72 Ruby Ln. Lot # 7 342-B-25

# 05-1263

ONE AND TWO FAMILY	PLAN REVIEW	CHECKLIST
Soil type/Presumptive Load Value (Table R401.4.1)	2500	
Component	Submitted Plan	Findings Revisions Date
<b>STRUCTURAL</b> Footing Dimensions/Depth (Table R403.1 & R403.1(1)), (Section R403.1 & R403.1.4.1)	8" x 16" Frost depth	OK
Foundation Drainage, Fabric, Damp proofing (Section R405 & R406)	4" perf pipe - both Asphalt ? Filter	OK Ted notes
Ventilation/Access (Section R408.1 & R408.3) Crawls Space ONLY	N/A	
Anchor Bolts/Straps, spacing (Section R403.1.6)	1/2" @ 6' O.C. 1' corners	OK
Lally Column Type (Section R407)	3 1/2" lally steel/concrete	
Girder & Header Spans (Table R 502.5(2))	5'0 spans	5'9 max OK
Built-Up Wood Center Girder Dimension/Type	3-2x10 w/edge br steel on 2nd fl -	Need spec - condition (2)
Sill/Band Joist Type & Dimensions	2x6 PT 2x8 box	
First Floor Joist Species Dimensions and Spacing (Table R502.3.1(1) & Table R502.3.1(2))	2x8 16" O.C.	OK

CBL
342-B-25
Lot # 17

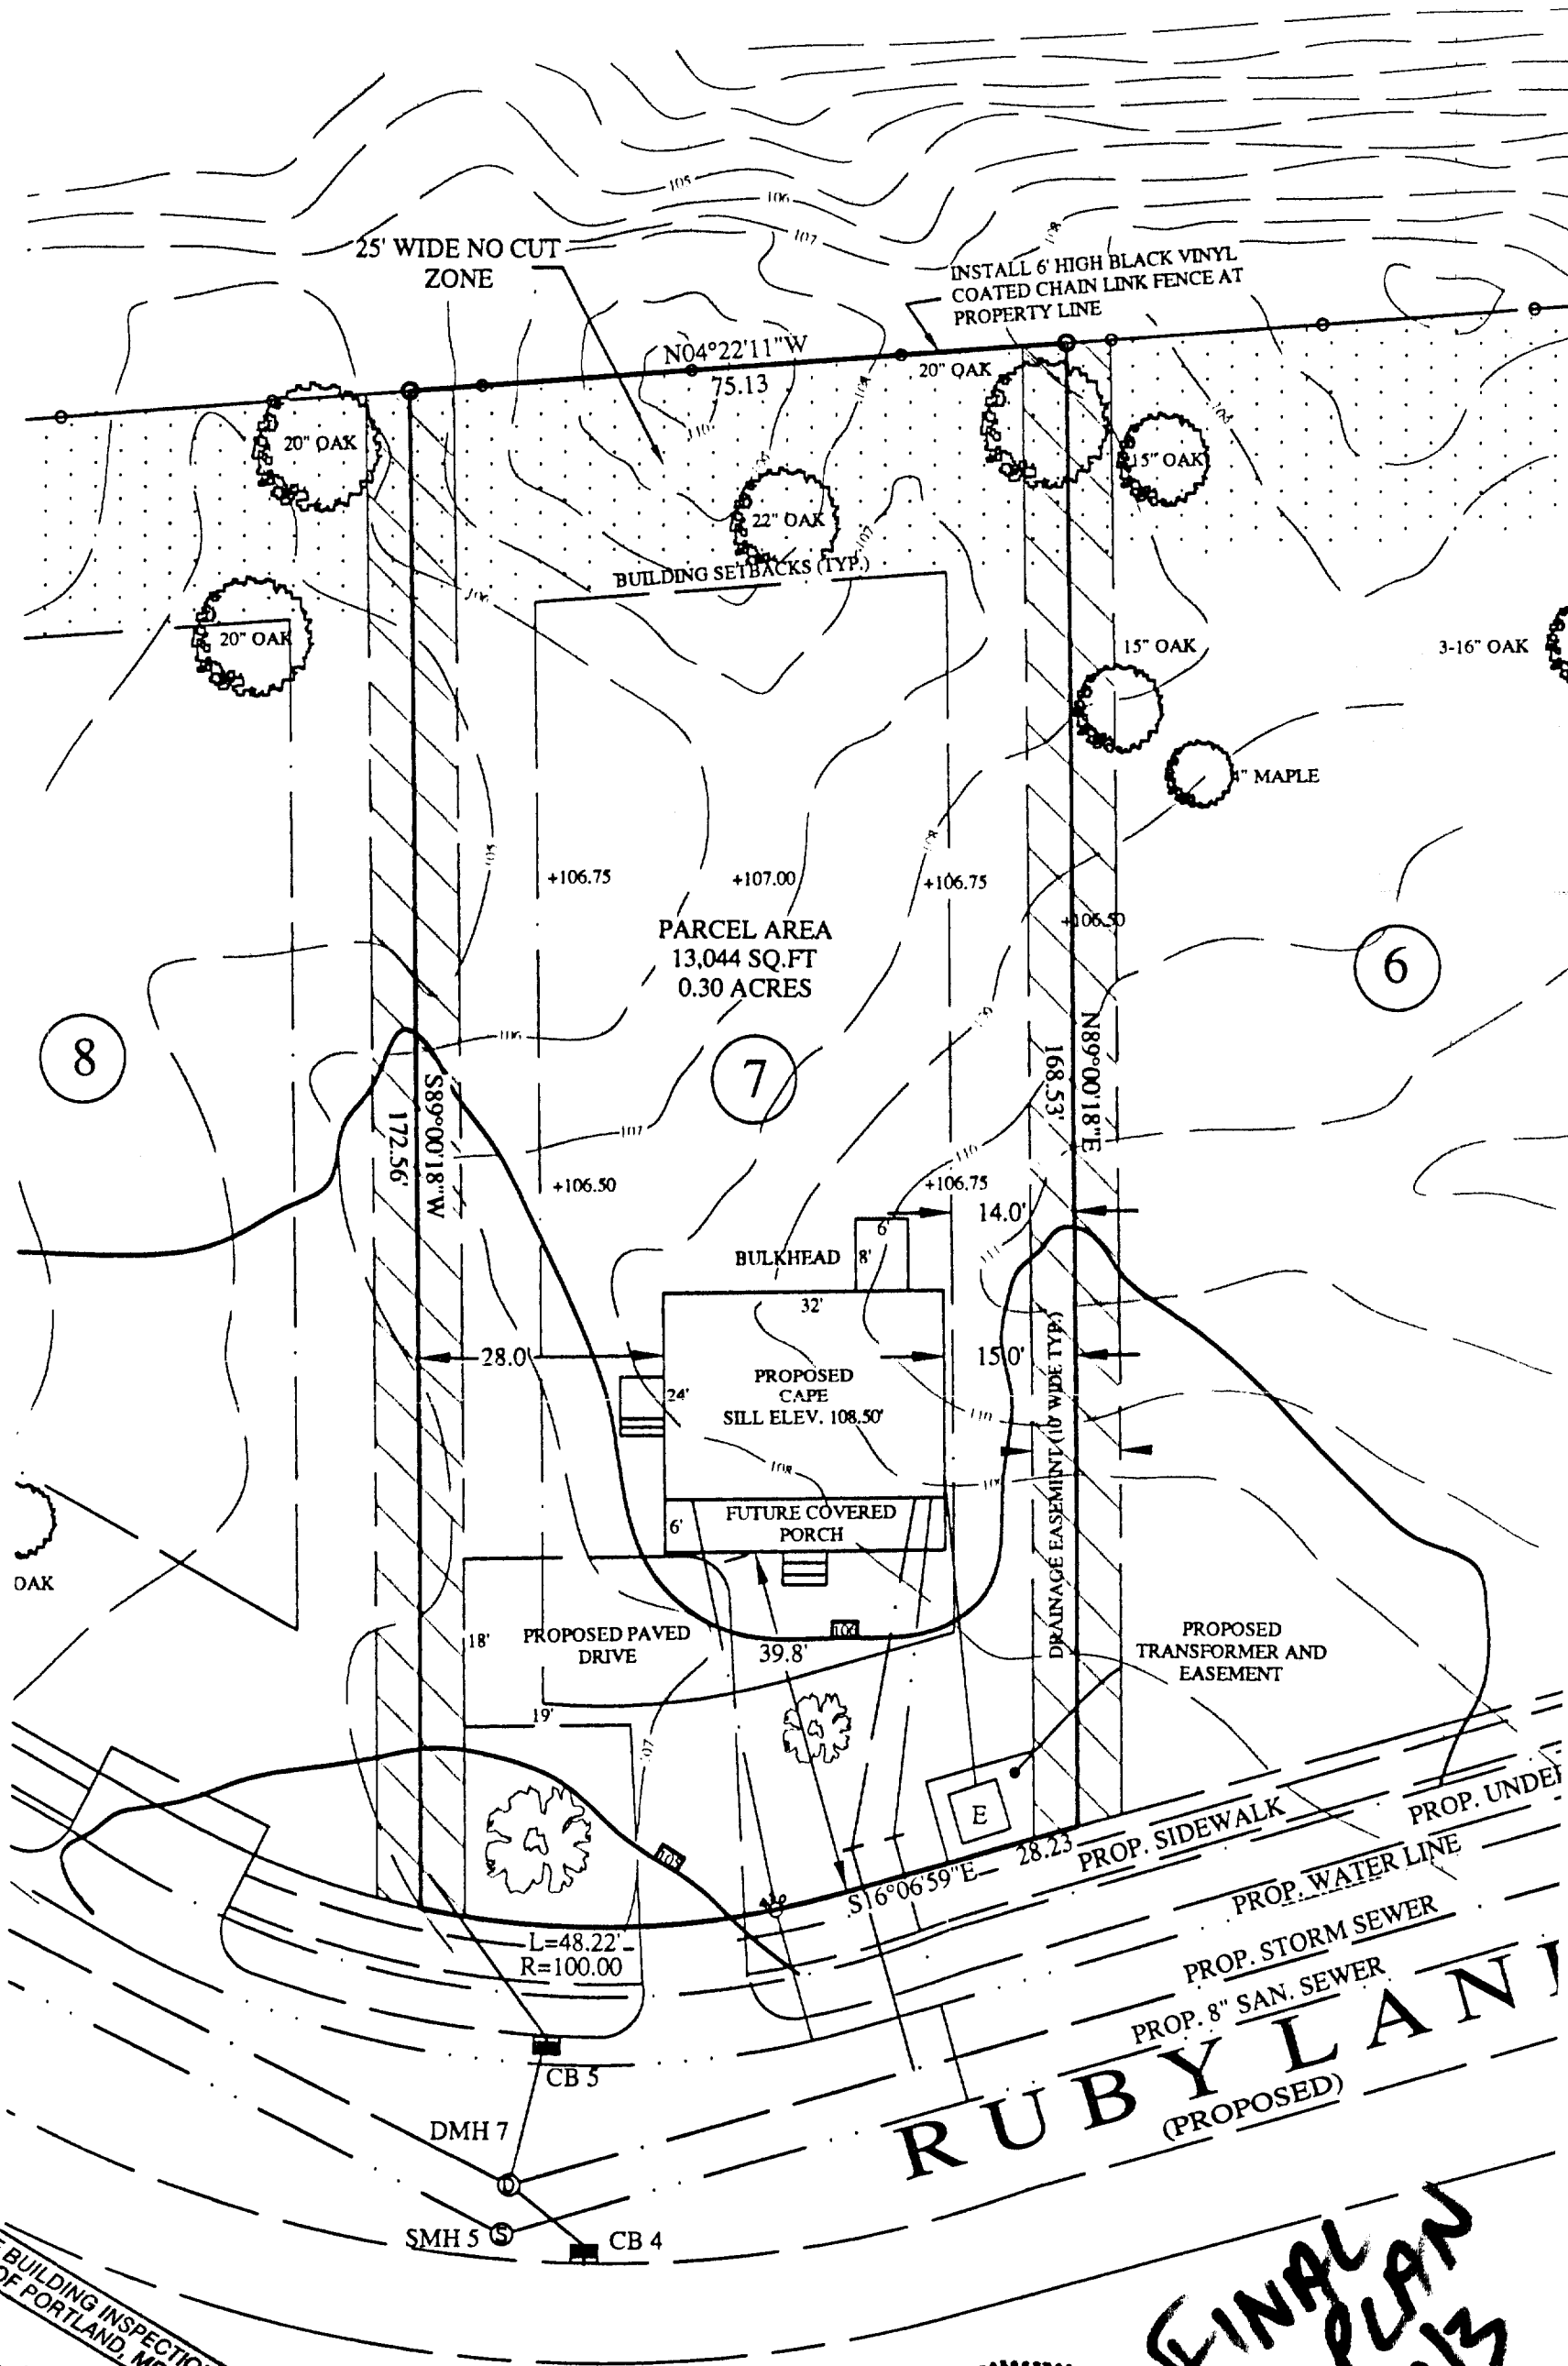
25' NO cut area in rear of property  
NO DAY LIGHT BASEMENT SHOWN
